WELWYN HATFIELD COUNCIL – DEVELOPMENT CONTROL
DELEGATED REPORT

APPLICATION No:	S6/2011/2817/FP
APPLICATION Site:	1 The Cottages

This application seeks full planning permission for the erection of two storey side extension, alterations to windows and doors on rear elevation and insertion of rooflight windows. The two storey side extension would measure approximately 7.1m in depth and 3m in width. The extension would be set in approximately 600mm from the front elevation of the application dwelling and approximately 850mm from the main rear elevation. The roof would be gabled in design with a ridge height of approximately 6.8m which would be approximately 900mm below the main ridge of the dwelling. The roof would feature a dormer to the front and rear with windows serving the first floor accommodation. The extensions would be finished in materials to match the existing dwelling.

**Drawing Title**  
GENERAL ARRANGEMENT PLANS AND  
ELEVATIONS AS PROPOSED  
OPTION 1

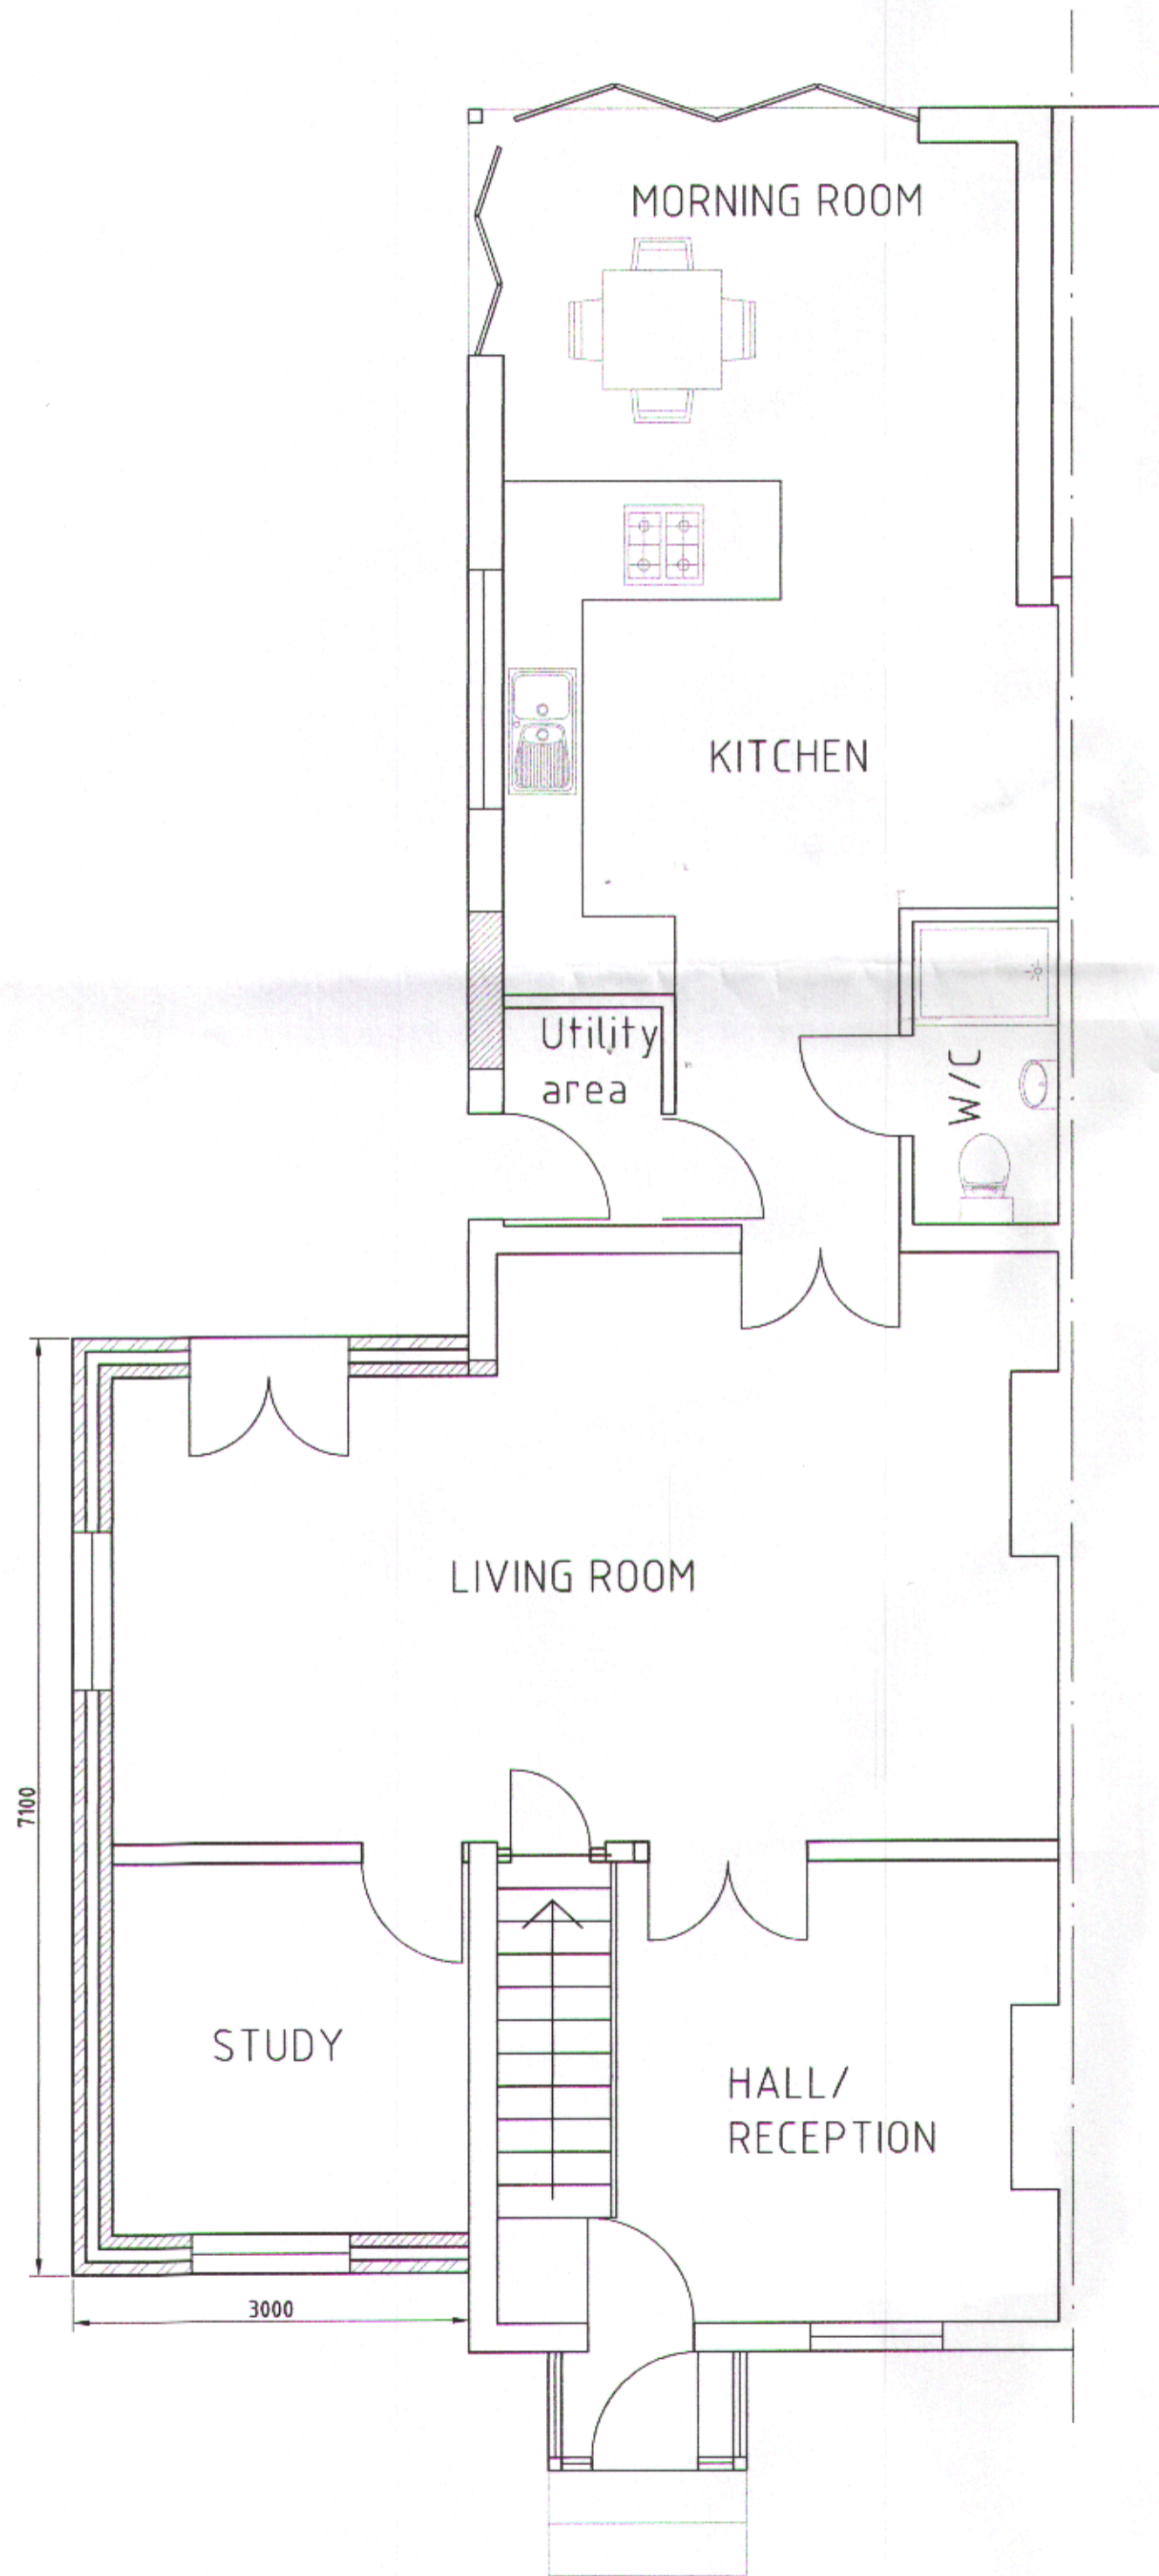
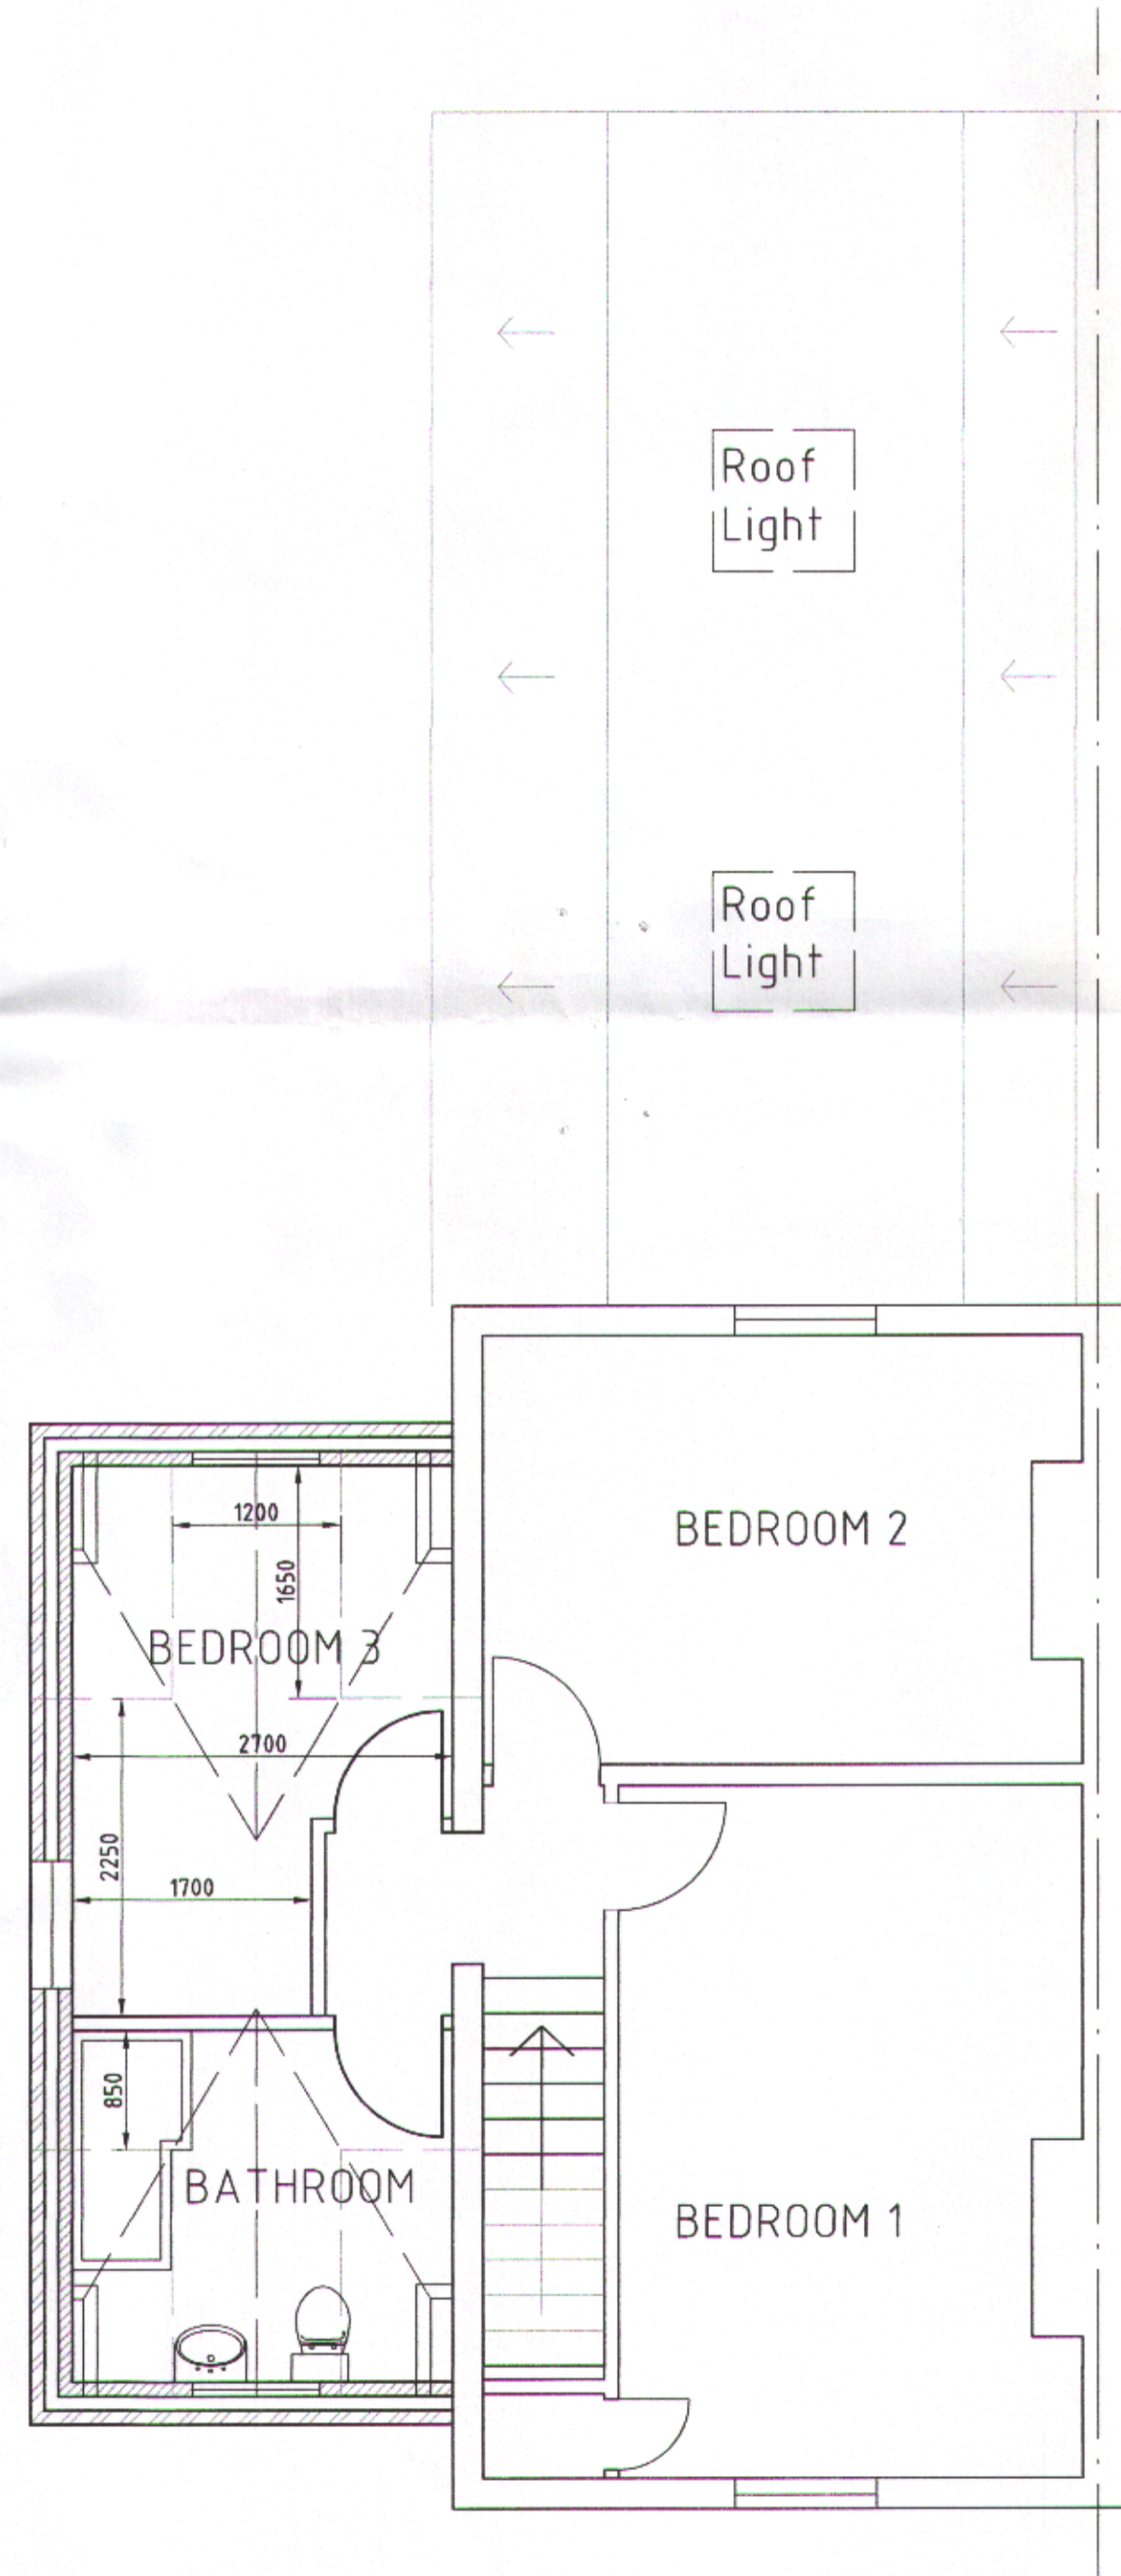
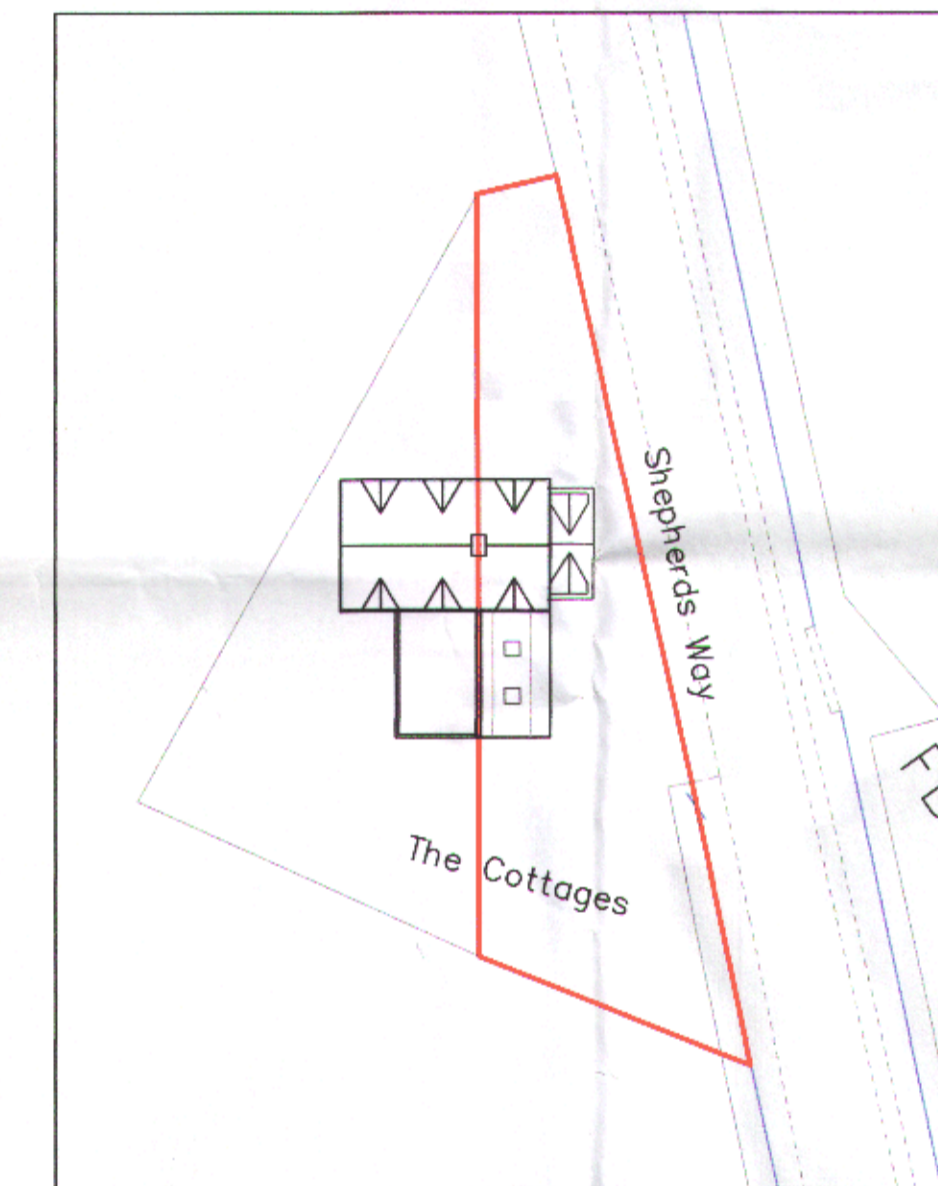
The proposed extensions would result in a total floorspace of approximately 162sqm which is equivalent to a 76% increase over-and-above the original dwelling. The footprint would increase to approximately 101sqm or a 90% increase over-and-above the original dwelling (refer to historic drawings on this file).

In terms of the effect of the extension on the openness of the Green Belt, the proposed increase in volume would materially increase the bulk and mass of the dwelling thereby reducing the openness of the Green Belt. Due to the orientation and the close proximity of the application dwelling to the highway at the side of the site, the two storey extension would be highly visible from viewpoints travelling along Shepherds Way. The increase in bulk and massing at a high level would result in more prominent structure than the existing dwelling and a reduction in the openness of its immediate surroundings. The proposed development would, therefore, have an adverse visual impact on the appearance of the surrounding countryside to the detriment of the openness, character and visual amenity of the Green Belt contrary to PPG2 and Policy RA3.

1. The proposed extensions would result in a disproportionate increase in the size of the original dwelling that would fail to appear as a limited extension to the dwelling. Furthermore, the proposed development as a result of its prominence, bulk and design would significantly diminish the openness of this part of the Green Belt to the detriment of the character of the area. The proposal is therefore inappropriate development within the Green Belt where the applicant has failed to prove to the satisfaction of the Local Planning Authority, that the harm, by reason of its inappropriateness is outweighed by other considerations contrary to the requirements of Policy RA3 of the Welwyn Hatfield District Plan 2005 and Planning Policy Guidance Note 2: Green Belts.
